Section 96(1A) Development Application Statement of Environmental Effects

161 Sussex Street, Sydney

Section 96(1A) Modification 1 to SSD_7014

August 2016 ■ 15190

Drawing Title:
NORTH & SOUTH ELEVATIONS
Drawing Number:
A-DA2-0302
Revision:
4
Scale:
1:200 @ A3

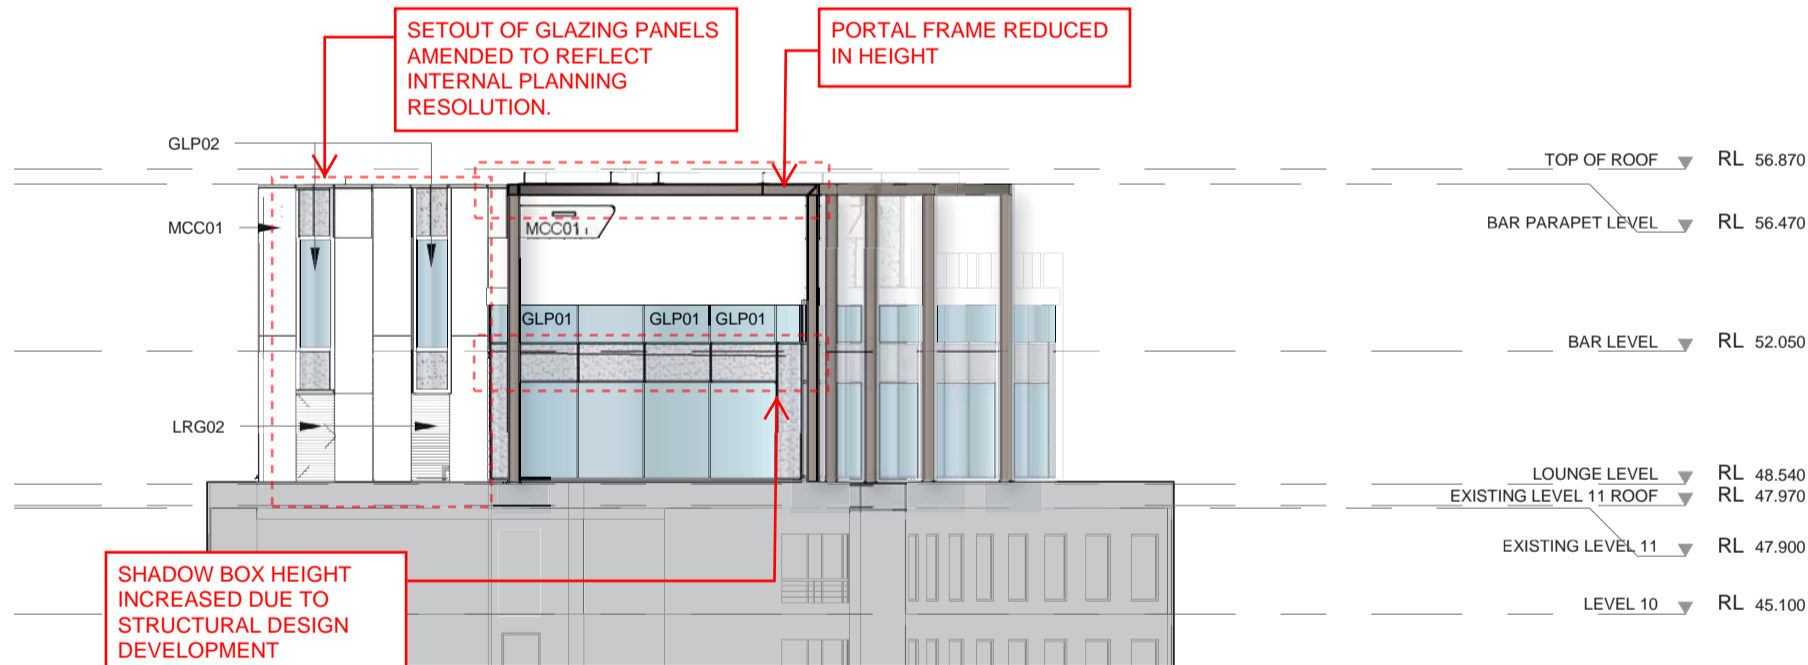
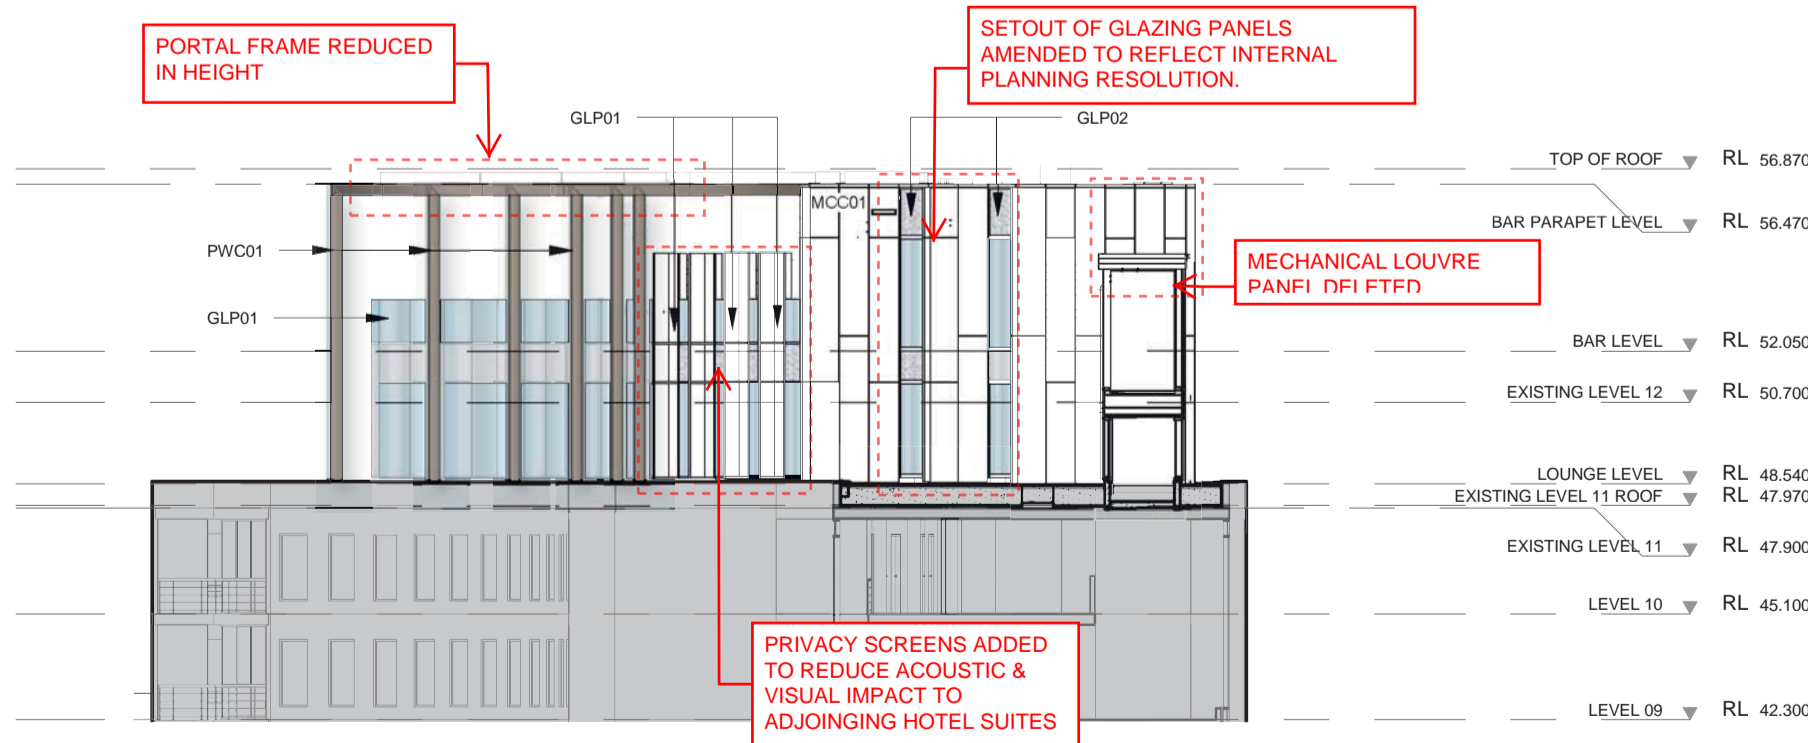
At the southern elevation of the bar and lounge structure, it is proposed to install fixed vertical louvres. These have been incorporated to minimise the potential for impact of the rooftop bar and lounge structure on the neighbouring hotel suites which are part of the same Four Points Hotel development. These louvres are indicated in red within **Figure 5** below.

Drawing Title:
EAST & WEST ELEVATIONS
 Drawing Number: A-DA2-0301
 Revision: 5
 Scale: 1:200 @ A3

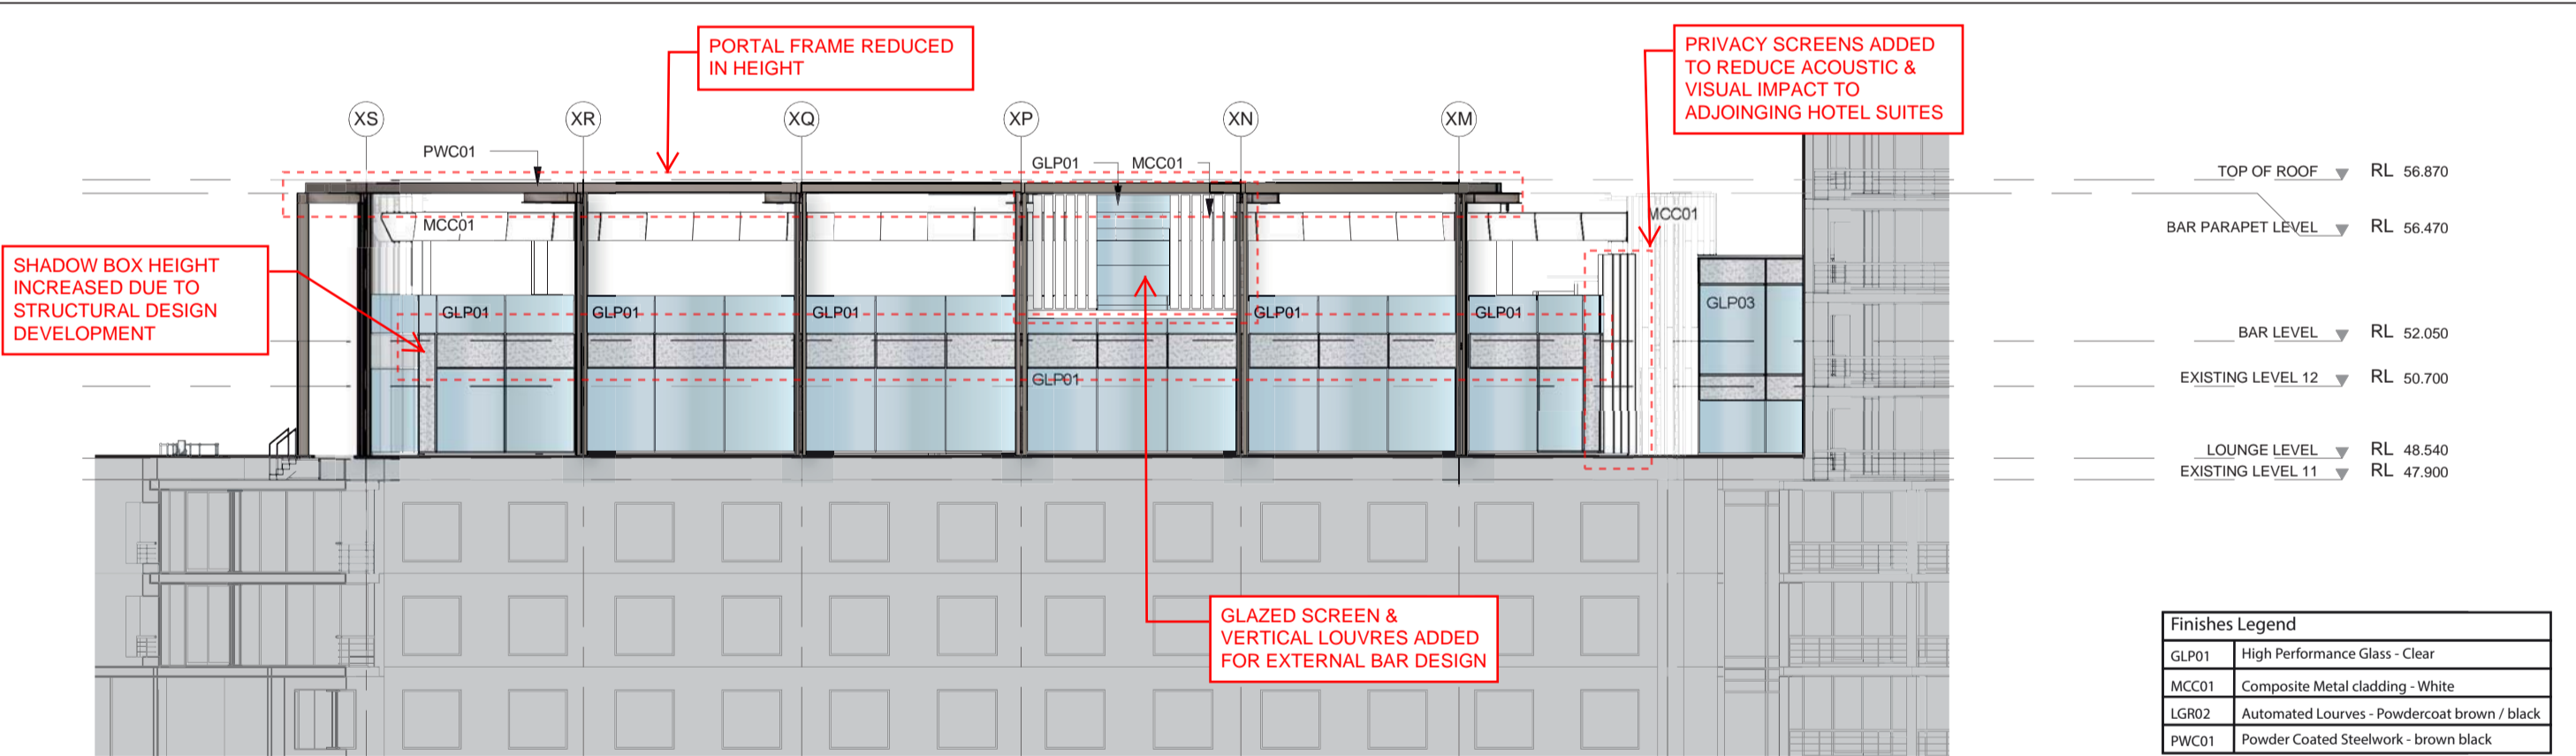
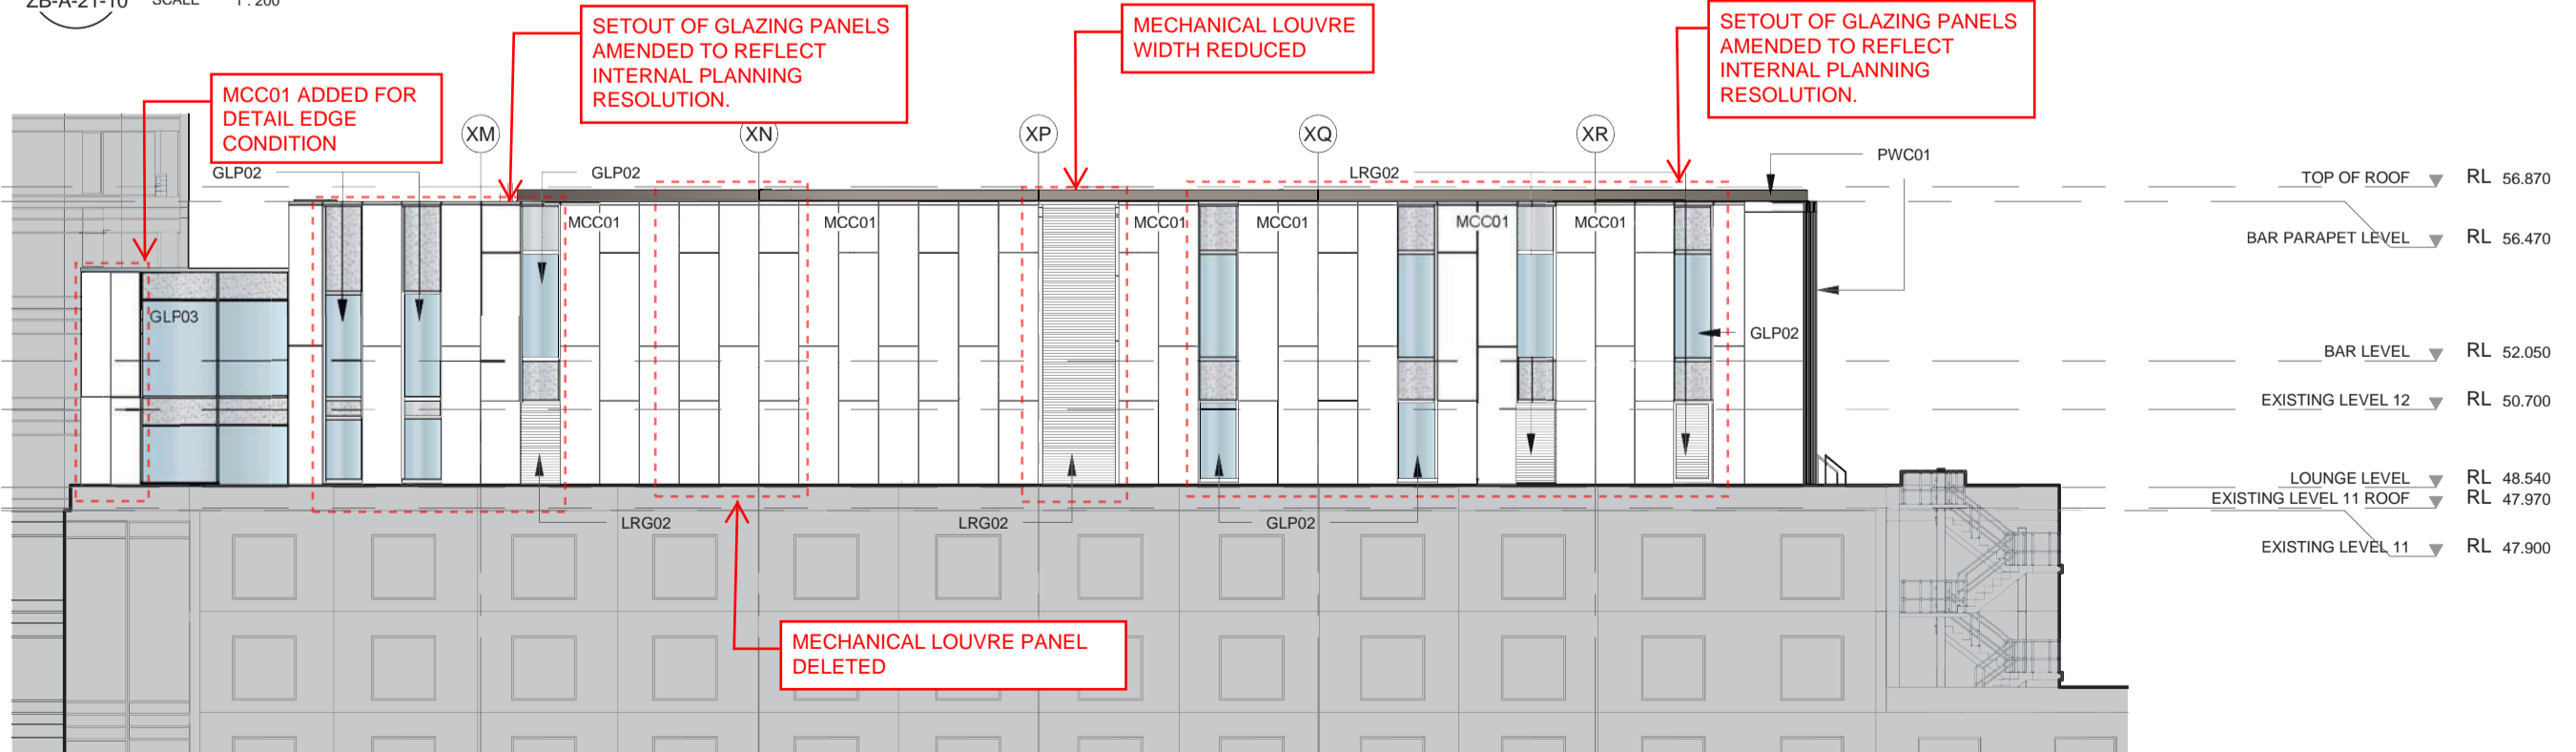
The proposal incorporates various minor amendments to external glazing, cladding, and plant louvres on all elevations, however the majority of changes relate to the eastern elevation, facing Sussex Street.

The overall number of window openings has been reduced from ten (10) to nine (9), which is a minor increase in width to some openings. This is a result of the coordination of the interior use of the spaces with the external appearance, which is a direct result of the detailed design development phase of the project. However it is noted that overall, the general level of glazing provided is consistent with the approval and does not give rise to any increased overlooking or visual privacy impacts to the neighbouring tower located to the east, on the opposite side of Sussex Street.

Further, minor amendments have been made to reduce the size, relocate or delete some external plant louvres. This corresponds with the design development and final specification of plant equipment for the building, which has recently occurred.

The western elevation is proposed to be modified to allow the addition of a glazed screen and two sets of white composite metal vertical louvres. The integration of these into the external structure are necessary as a backing to support the installation of the final interior bar design. Refer to **Figure 4**.

As noted above in **Figures 3** and **4**, the approved shadow box on the glazed curtain wall (or non-transparent glazed panel at slab level) has been increased in height on all facades. This modification is proposed in response to the design development phase for the structure and the desire to provide sufficient height in concealing the slab edge and associated services within this zone.

In addition, there has been a slight reduction in the height of portal frame roof structure. This is a minor revision to match the interior planning of the bar and lounge space and offers a more visually attractive space when viewed internally. Refer to **Figures 3** and **4**.
